**AN COIMISIÚN  
PLEANÁLA FURTHER  
INFORMATION REQUEST**

**Our Case Number: ABP-320089-24**

**Date: 15 May 2025**

**Re: Wind Farm Comprising of 11 Wind Turbines and Associated Infrastructure.**

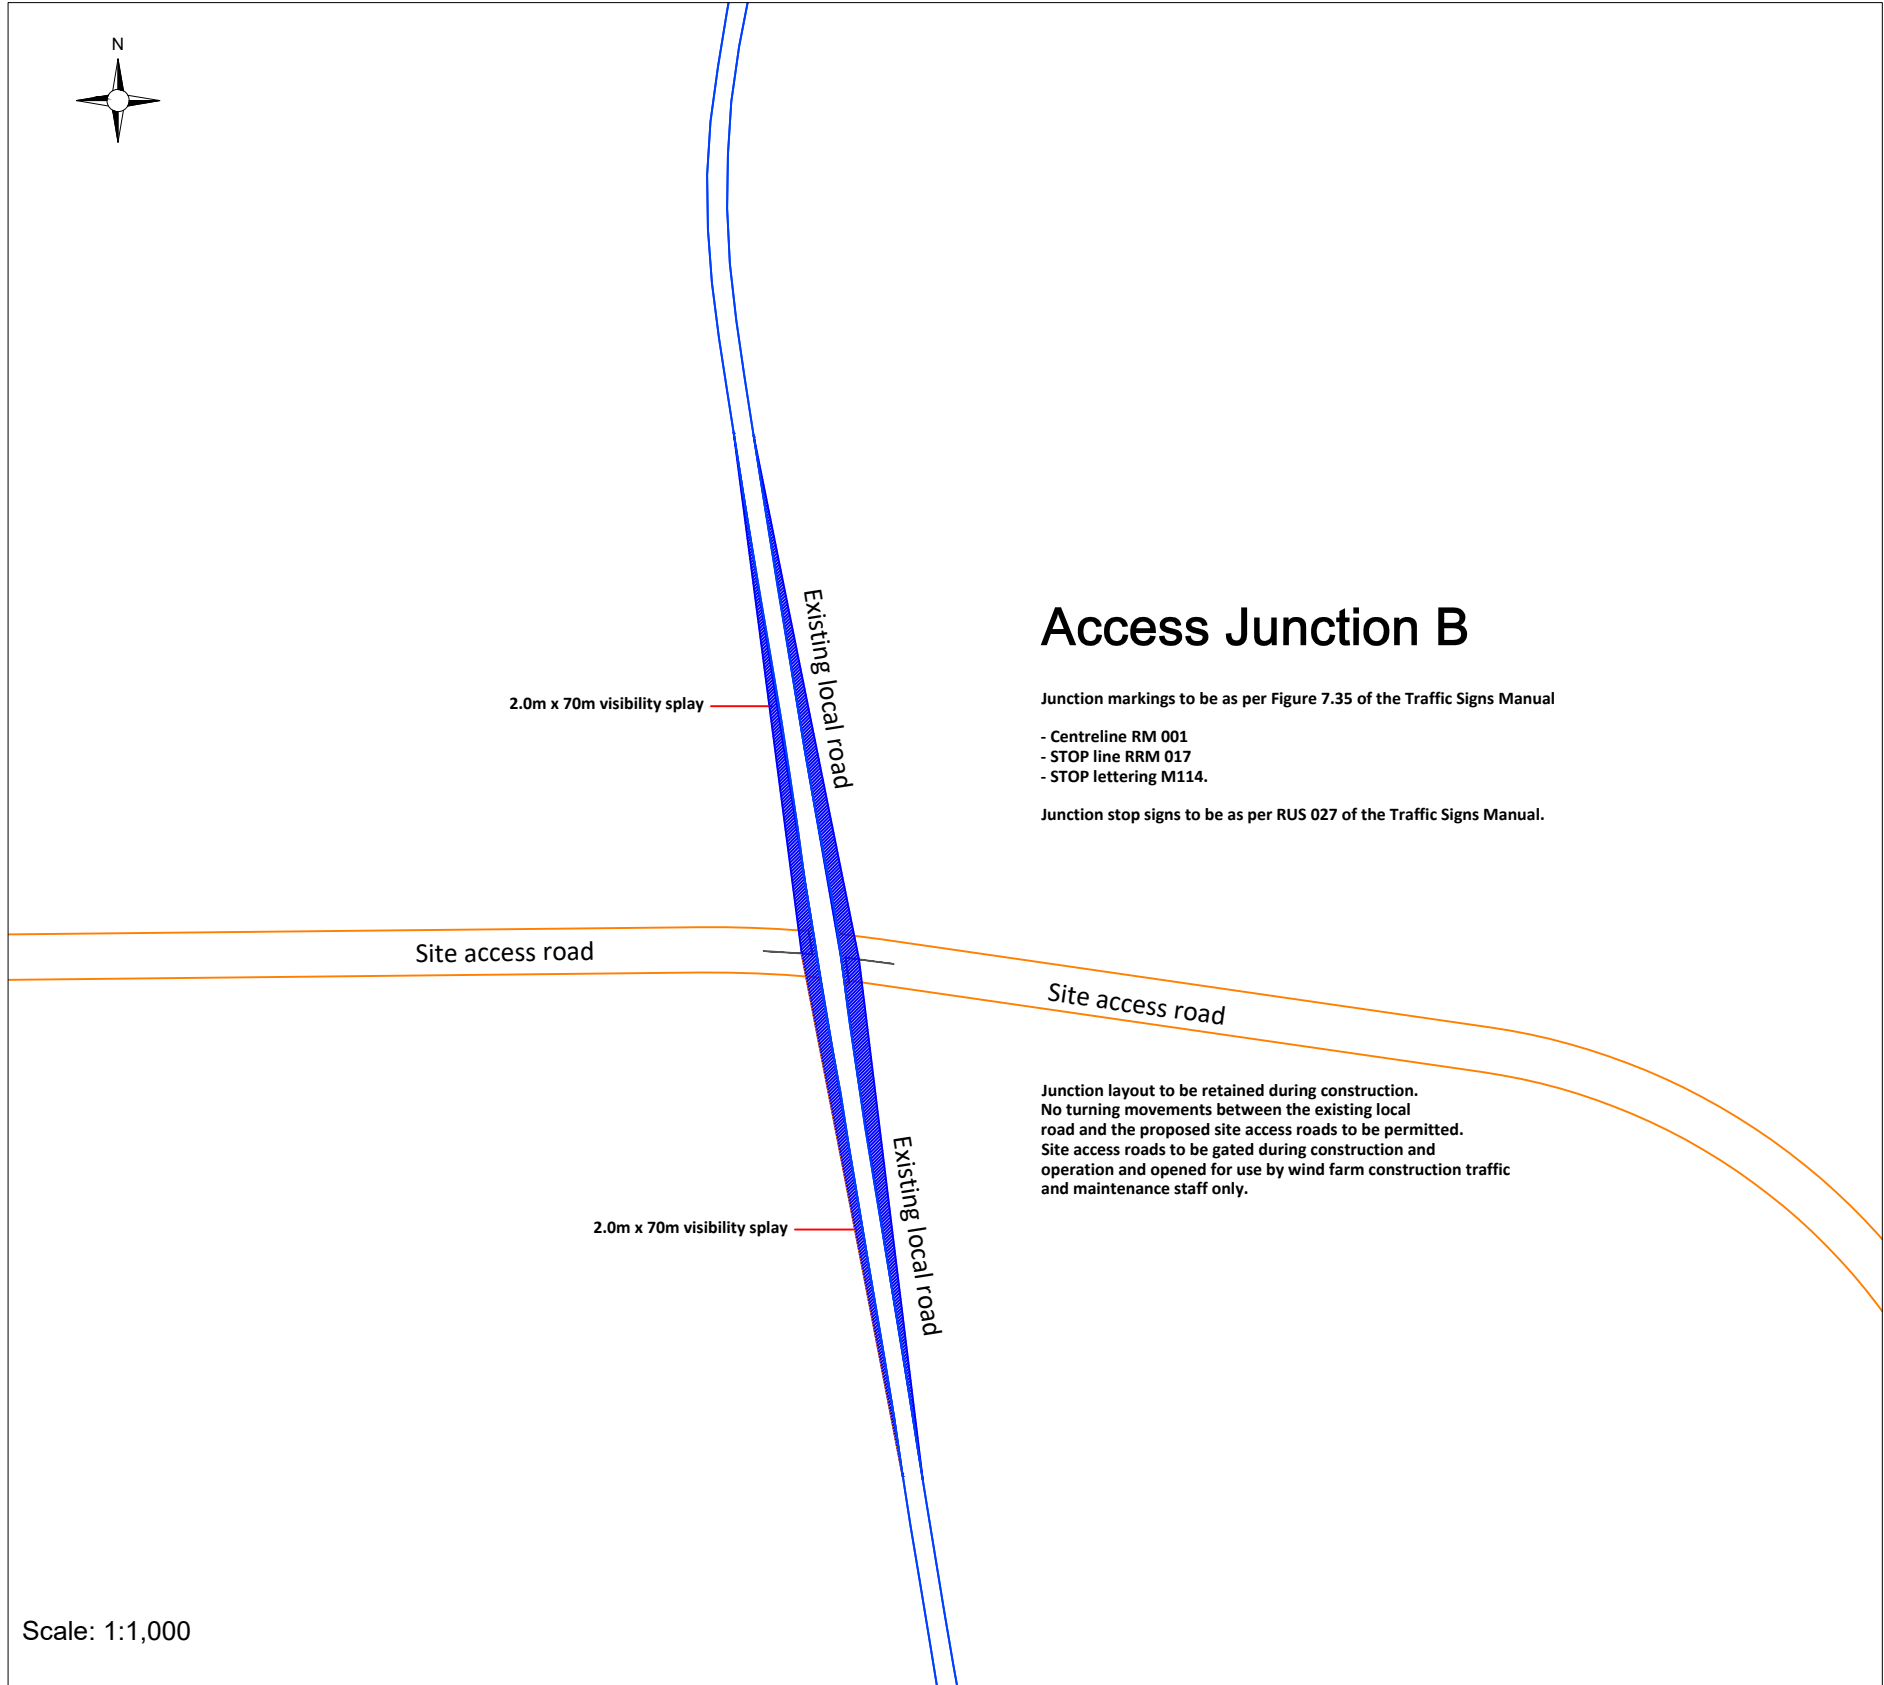
2. The proposed development in its current form fails to accord with Development Management Standard 28 of the Galway County Development Plan given the restricted eastern visibility splay from the construction entrance on the R328 (Junction A). Notwithstanding the mitigation measures proposed, you are requested to install an Automatic Traffic Counter (ATC) to determine the 85th percentile (design speed) at this location. Demonstrate the vertical envelope of visibility (i.e. intervisibility in relation to crest/sag road profile) onto the R-328 in accordance with the relevant TII standards.

3. Submit a proposed boundary treatment plan for the access with the R329 (Junction A) following the completion of the abnormal load delivery phase and following completion of the overall construction phase of the development.
